PLANNING CONSULTATION RESPONSE

Application No	2026/0081
Proposal	Change of use of first and second floors from 2no. flats (Class C3) to one 4-bed HMO (Class C4) (Part Retrospective).
Address	70 Pontefract Road, Barnsley, S71 1AB
Date of Consultation Reply	11.02.26
Consultee	Stacey Fieldsend-Case Management Officer

FLOOR PLANS

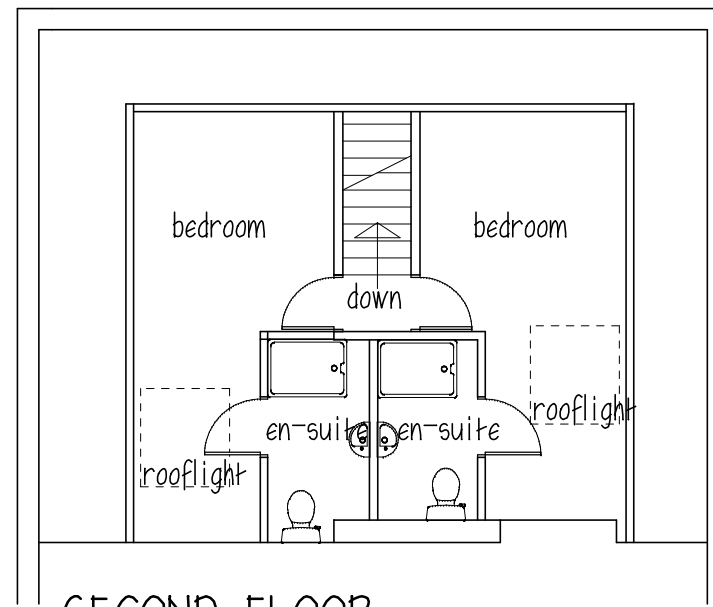
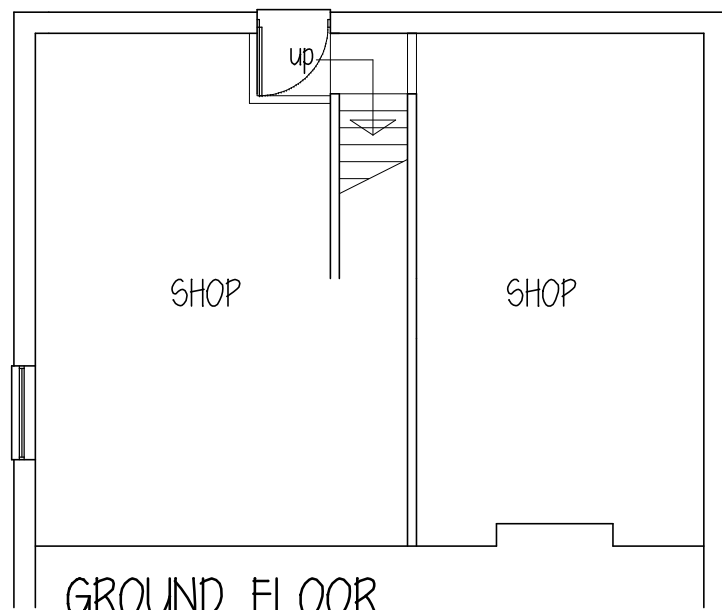
Although the room measurements have not been provided, I estimate the first-floor bedrooms to be 7.28sqm & 8.74sqm, then 11.32sqm & 11.42sqm on the second floor.

As the rooms on the first floor are under 10.22sq metres, we would require separate communal living room and kitchen areas. Dining facilities should also be provided in a communal area.

All windows on the first floor will be fire escape windows.

Proof of 60-minute fire resistance necessary between the commercial business on the ground floor and HMO above.

Combined kitchen/dining room with a minimum size requirement of 11.5sq m plus living room of at least 11sq m.

1. Combined kitchen/dining room with a minimum size requirement of 11.5sq m plus living room of at least 11sq m.
2. All windows on the first floor will be fire escape windows.
3. Proof of 60-minute fire resistance will be necessary between the commercial business on the ground floor and HMO above.
